Re: Submission (SUB-61923959).

Pathways Cremorne Seniors Housing

Application No: SSD-49472213

Location: 50-88 Parraween Street, 59-67 Gerard Street, Cremorne 2090

BASEMENT PLAN

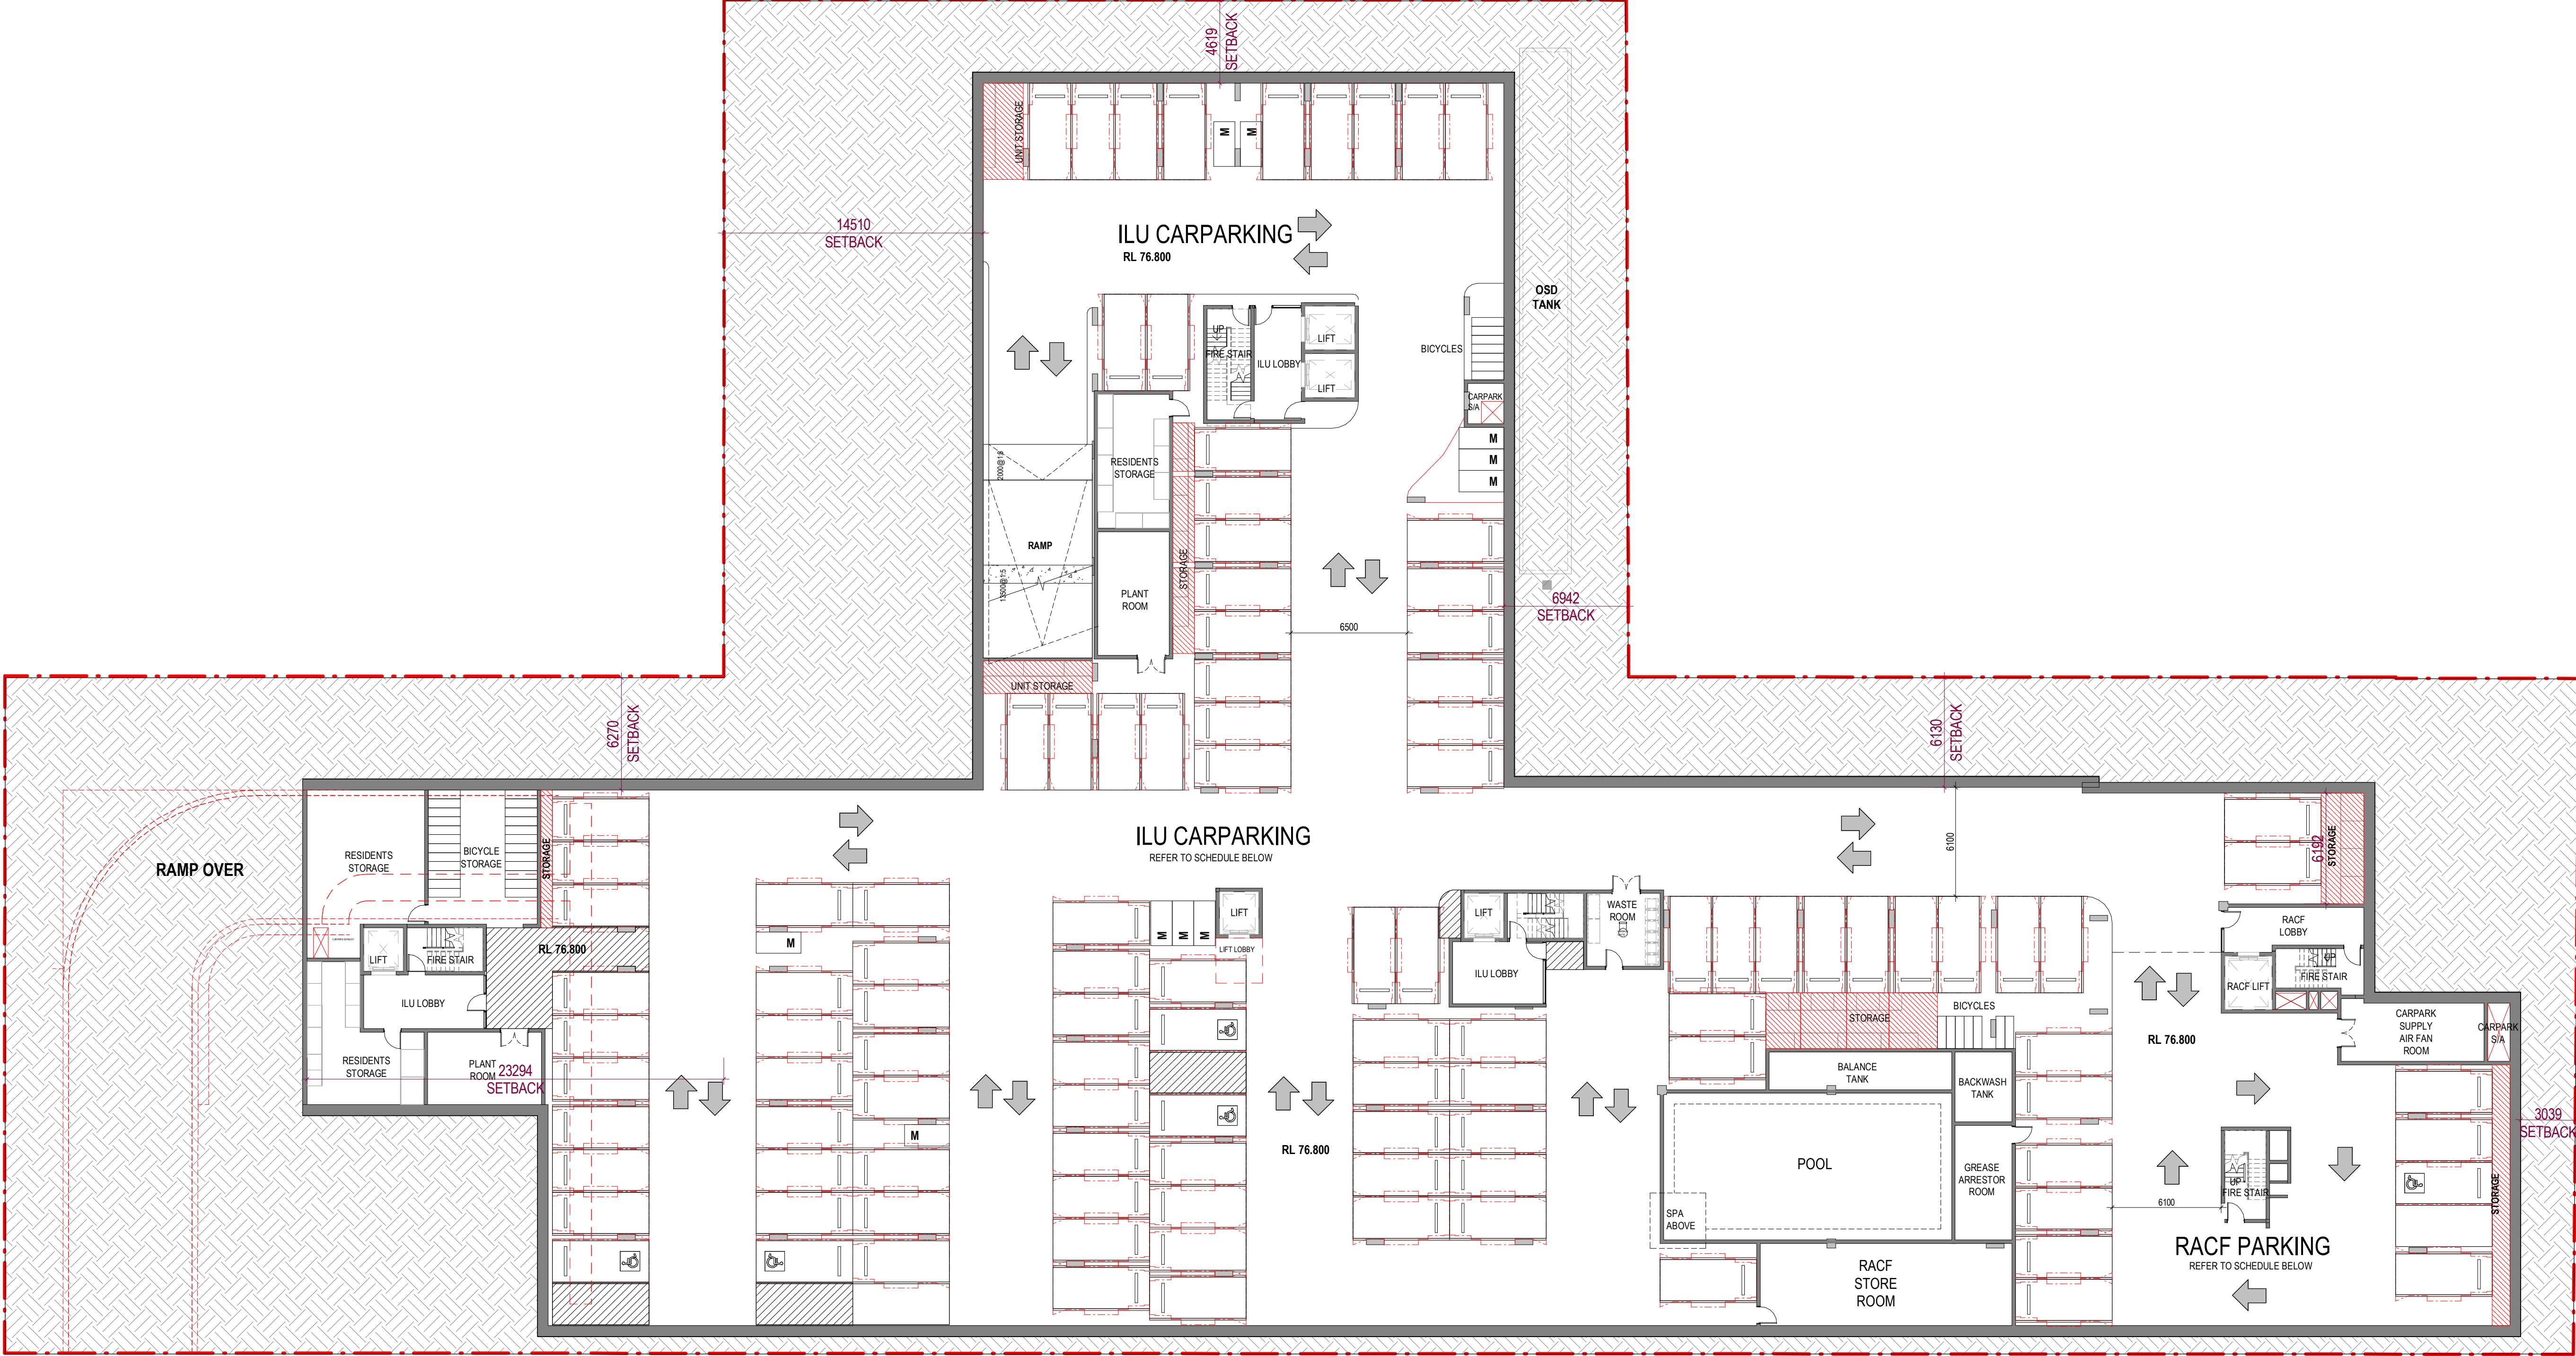
The underground carpark for 134 cars, 56 bicycles and 9 motor bikes will be serviced by a single driveway (entry & exit) on Parraween Street. Are any of the carspaces for visitors? Or do they park on the street, compounding the parking problem for residents and other users of Cremorne village? The Hayden Orpheum Picture Palace in particular creates a strong demand for parking.

56 bicycles seems an extraordinarily high number of spaces for Seniors riding bikes. Or will some (many?) of these be converted into carspaces after completion?

1 **SOUTHEAST ELEVATION**
(PARRAWEEEN STREET)

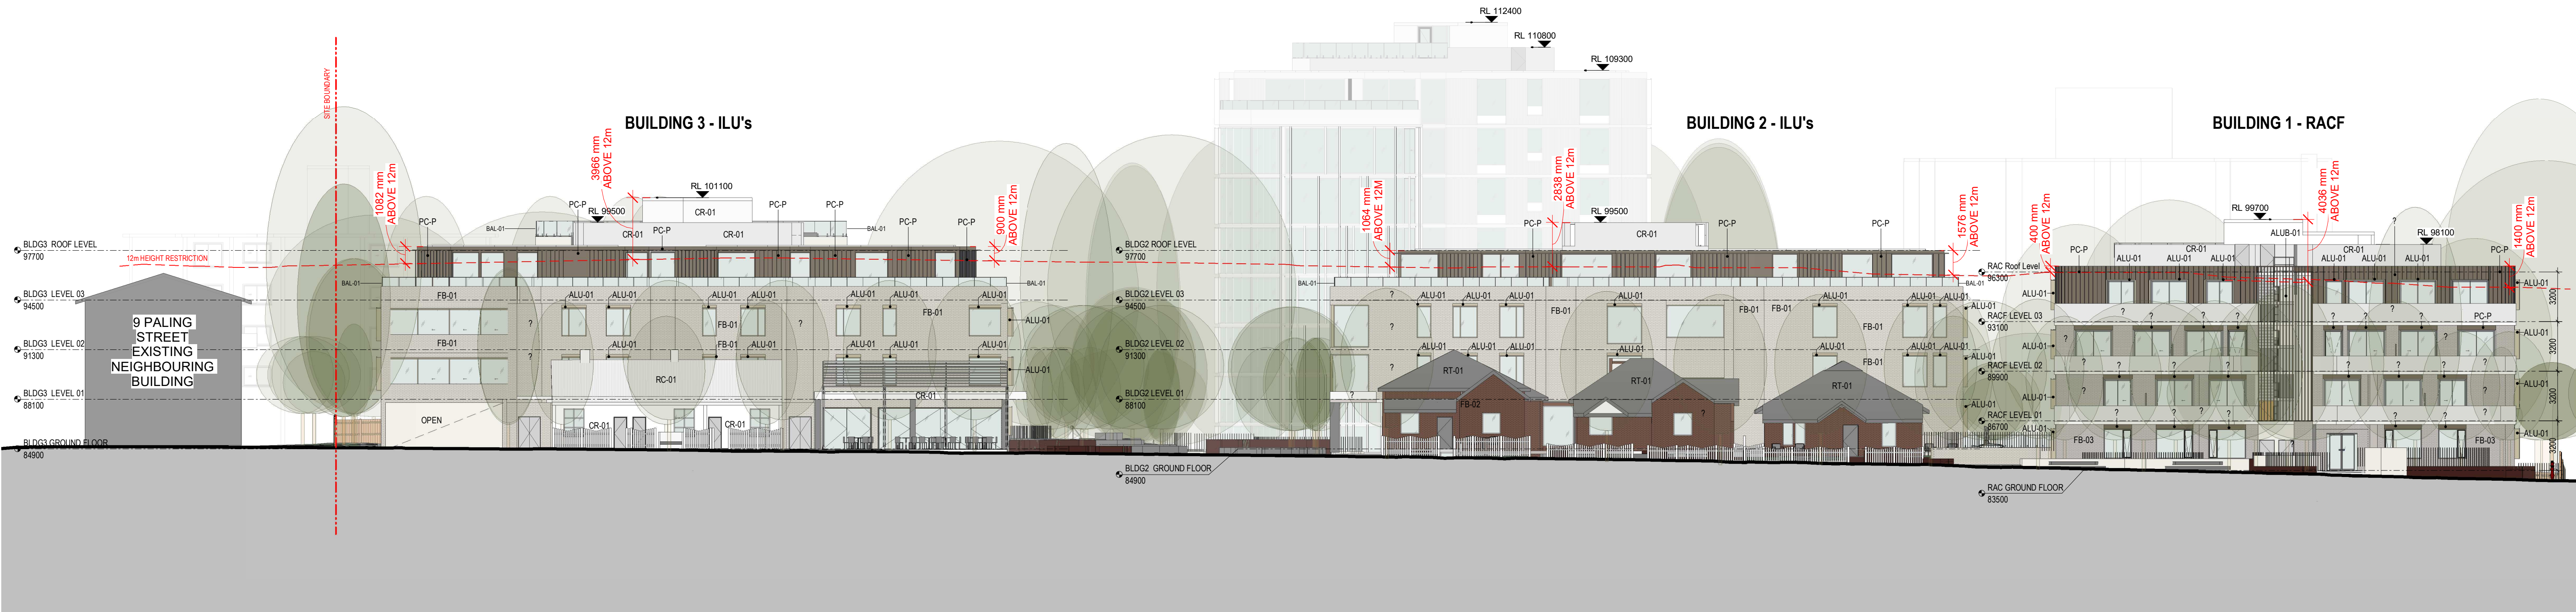
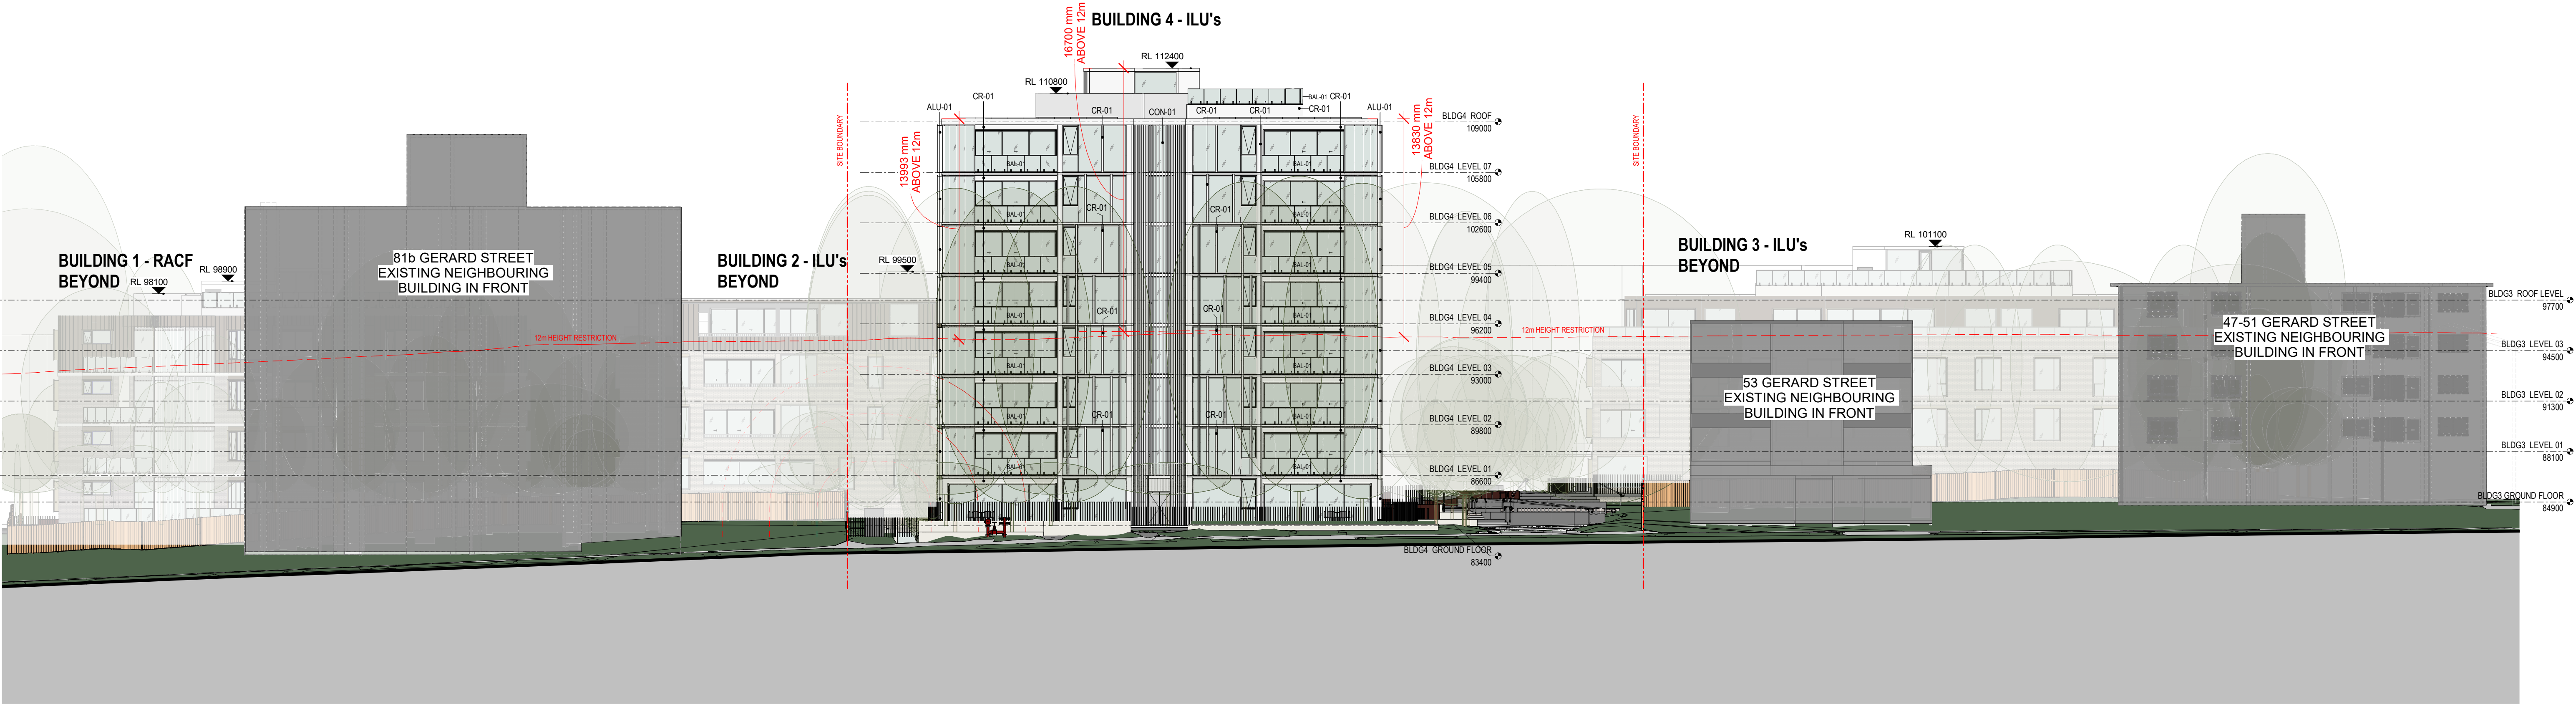
The proposed 28.66 metres building (supposedly 8 storeys, but would accommodate 9 storeys) is over twice the LEP zoning height of 12 metres, and along with the other 3 buildings proposed, represents a massive overdevelopment of the site and will dominate the frontages on Parraween and Gerard Streets.
